Reference No:	2023/62/92835/W
Site Address:	267, Cowcliffe Hill Road, Cowcliffe, Huddersfield, HD2 2NA
Description:	Erection of single storey side extension with front patio
Recommending Officer:	Joanna Rednall

HOUSEHOLDER DELEGATED REPORT

Application Number	2023/92835
Location	267, Cowcliffe Hill Road, Cowcliffe, HD2 2NA
Proposal	Erection of single storey side extension with front patio
Publicity end date	2 nd November 2023
Number of representations received	None
Kirklees Local Plan Allocation/Designation	
Extension to Time (EoT)	Yes / No / N/A EoT Date:
Recommendation	Conditional Full Permission

Scheme: -		
Single storey side extension		
Location: -		
267 Cowcliffe Hill Road		
Drawing Description: -		
Proposed Elevations		
Scale: -	Date: -	Dwg Number: -
1:100	June 23	04
Client: -		
Mr C Bird		
Amendments: -

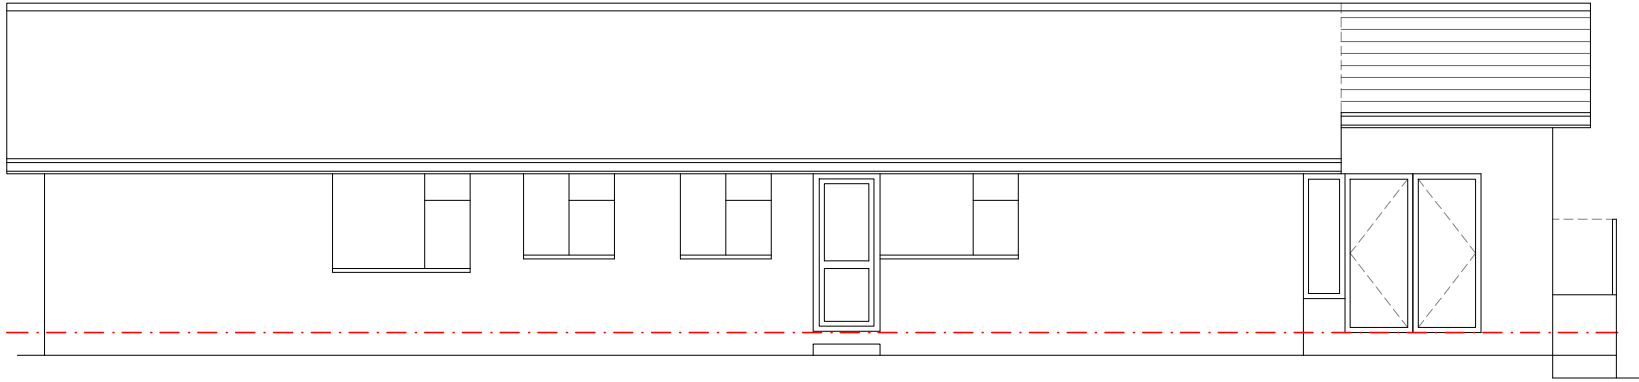
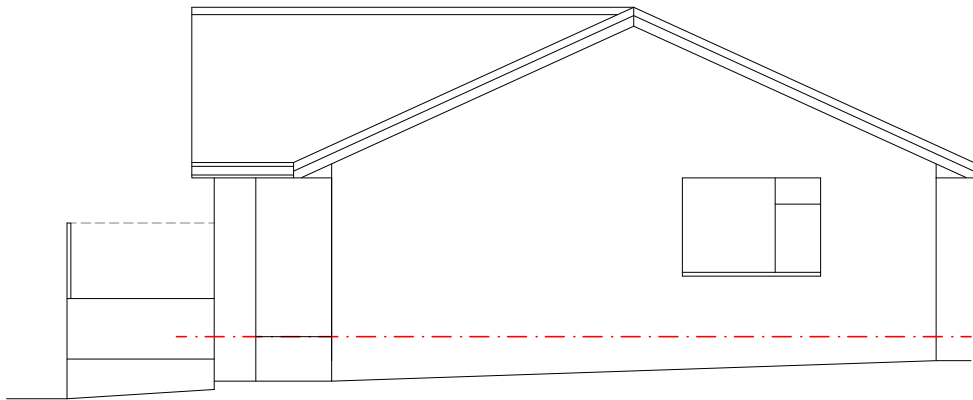
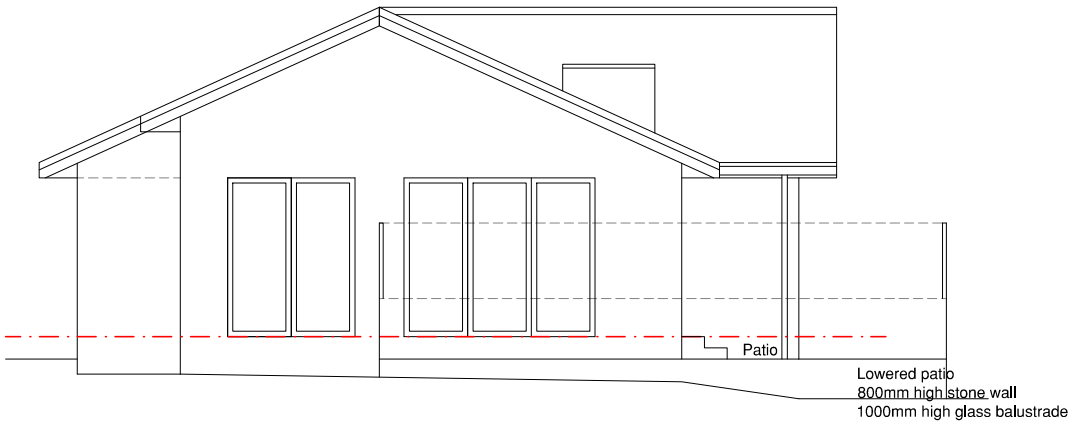
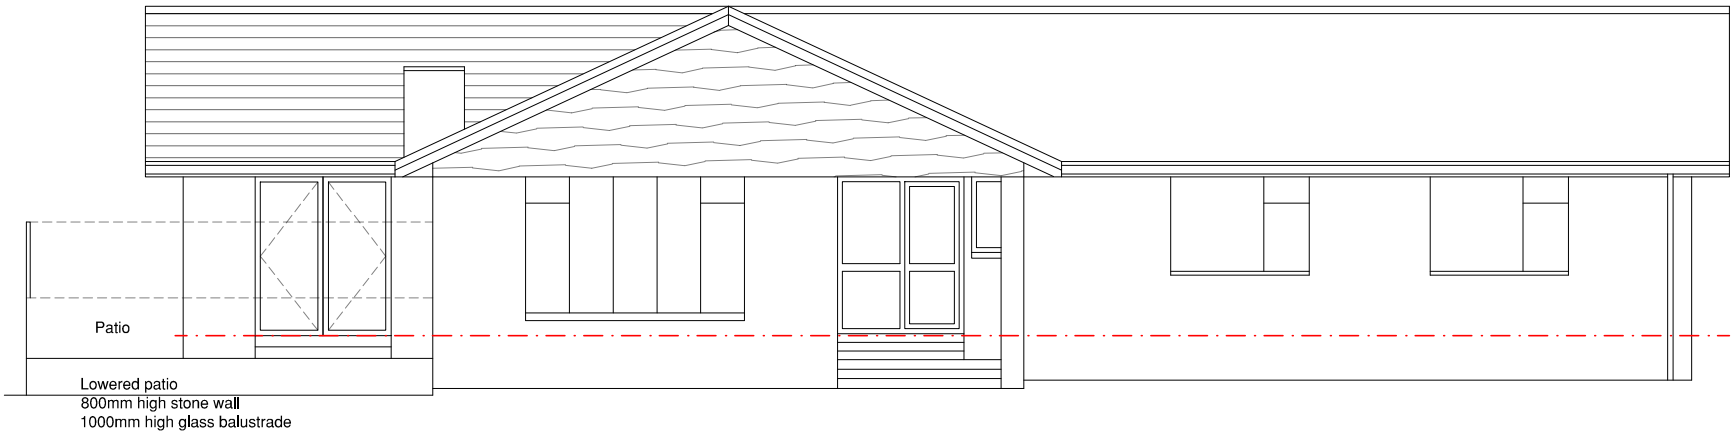
thirds of the width of the original house	
Not exceed a height of 4 metres		The extension is ~ 4.8 metres in height, however this does not exceed the height of the host dwellinghouse and the impact on visual amenity is limited
Be set back at least 500mm from the original building line to allow for a visual break	The extension is set back from the front elevation by 1.5 metres	
Corner plots should have:		
Facing in both directions to create two frontages, each with windows overlooking the street	There are proposed openings in both the northeast elevation and south west elevation	
Being set back from the existing building line on both streets	The extension does not encroach beyond the building line of the properties

Roof style	• KDP 1 and 2 of the SPD • Policy LP24 Design (a), (c) and (d) of the KLP • Chapter 12 of the NPPF	Gable roof to match the host dwelling	✓
Window proportions	• KDP 1 and 2 of the SPD • Policy LP24 Design (a), (c) and (d) of the KLP • Chapter 12 of the NPPF	Windows within south elevation are proportionate to existing dwelling	✓
Accessibility for all users	• KDP 17of the SPD • Policy LP24 Design (f) • Chapter 12 of the NPPF	Private domestic extension	✓

Scheme: -		
Single storey side extension		
Location: -		
267 Cowcliffe Hill Road		
Drawing Description: -		
Proposed Floor Plan		
Scale: -	Date: -	Dwg Number: -
1:100	June 23	03
Client: -		
Mr C Bird		
Amendments: -

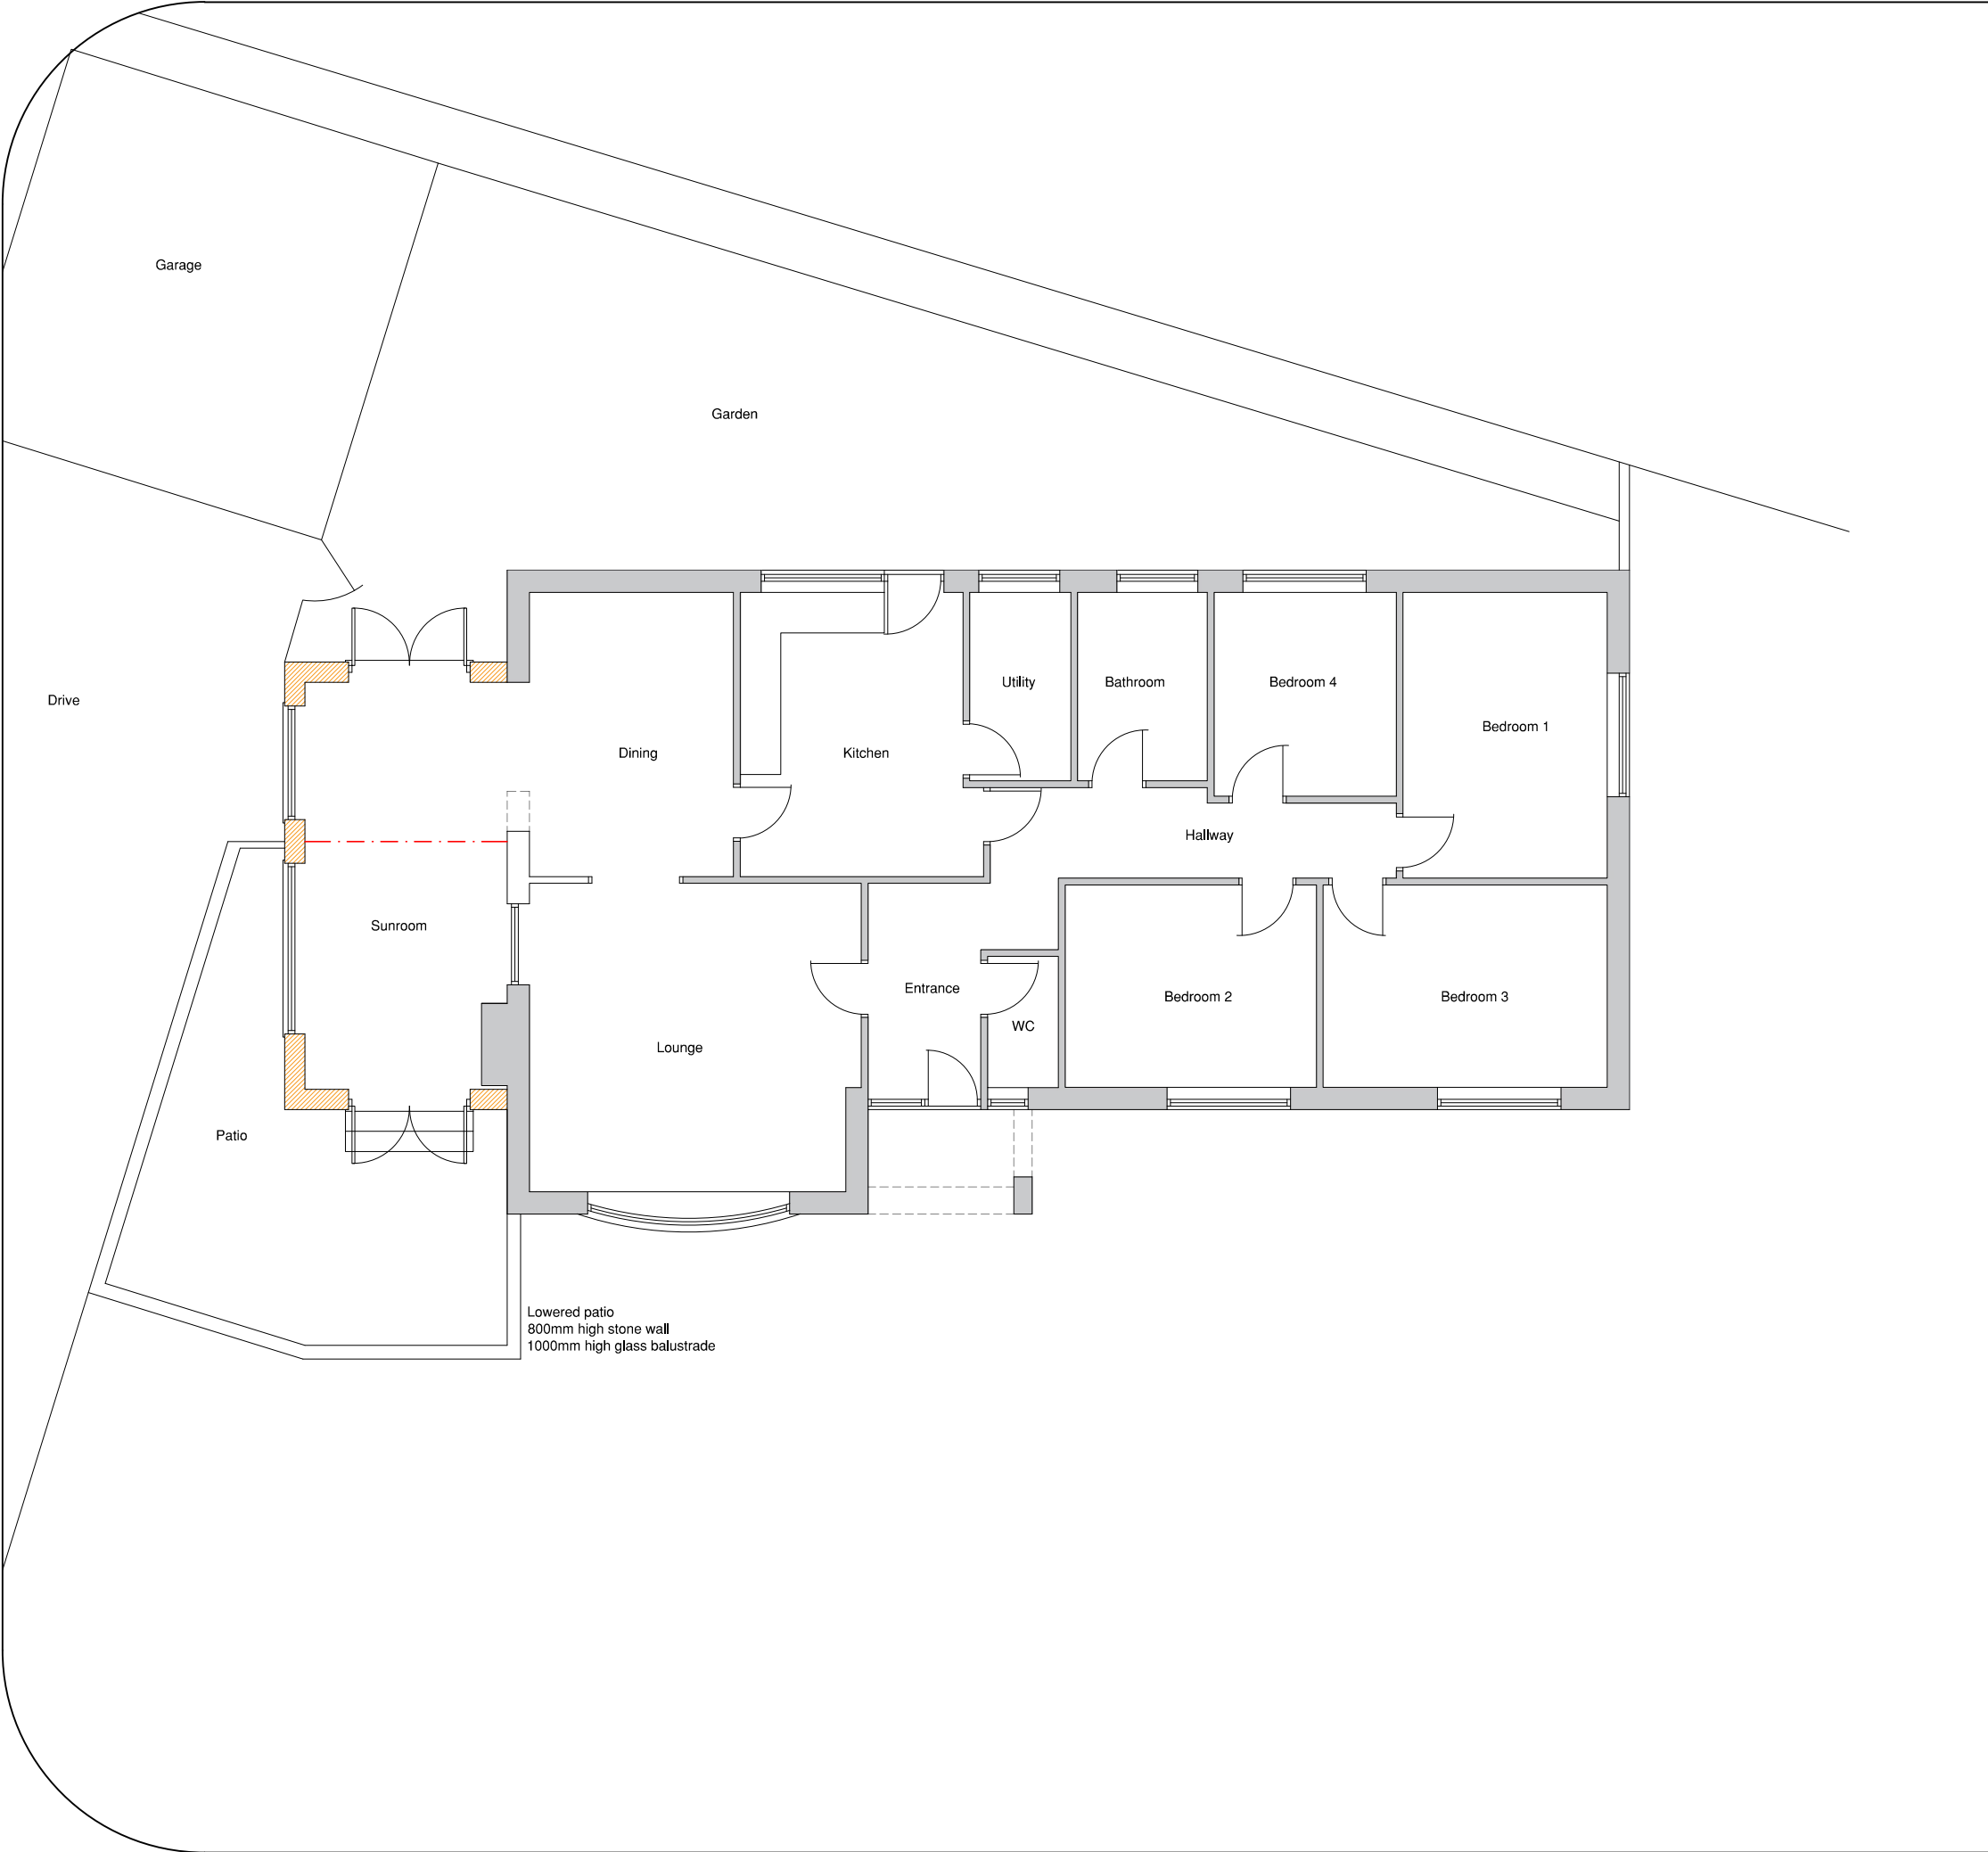
The application seeks permission for the erection of a single storey side extension with front patio. The side extension extends 3.3 metres from the side of the property and 6.6 metres along the property. The lowered patio extends 2.1 metres from the front of the property and curves 5.5 metres to meet the driveway. The patio would be enclosed with a 0.8 metre high stone wall and 1 metre high glass balustrade.
